Planning Consultation Response

Application No.:21/00014/FUL

**RE SURFACING AND MARKING OUT PUBLIC AND STAFF CAR
PARKING SPACES AND PROVISION OF BIN STORE.
HALSTEAD HALL, BRAINTREE ROAD, HALSTEAD**

Client: Stow Healthcare Group  
 Job Title: Halstead Hall Car Park  
 Drawing Title: Proposed extension to car parking  
 Scale: 1:500 @ A1 Drawn By: MS Date: December 2020  
 Job Number: 5636 Drawing Number: 02.A Status: Preliminary

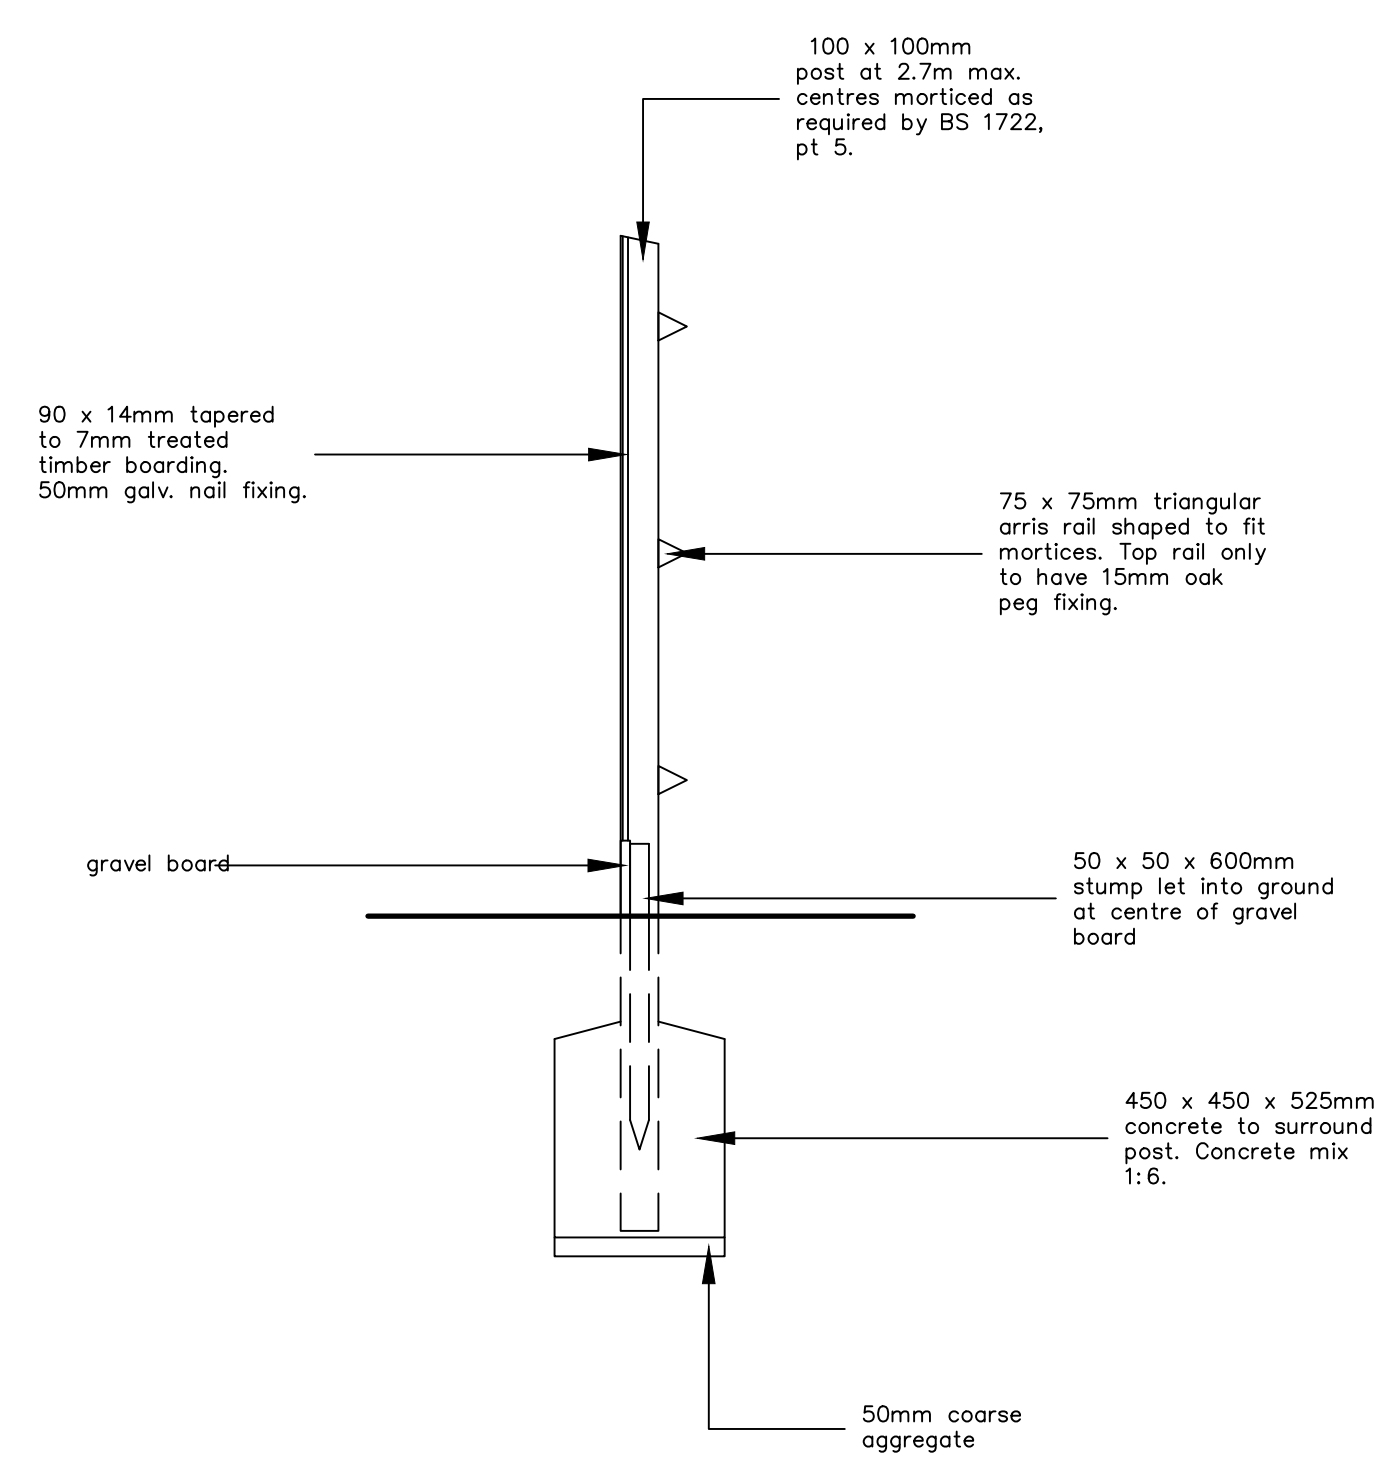
I note that the plans do not specify the surface type within the bin store. I would recommend that if the application is approved that the following condition be applied to facilitate adequate cleansing of the bin store area, and prevent harborage by pests.

1. The base of the bin store shall be constructed with a suitable load bearing concrete slab laid to a fall with strip gully connected to a suitably sized soakaway, to facilitate washing down of the area beneath the bins.
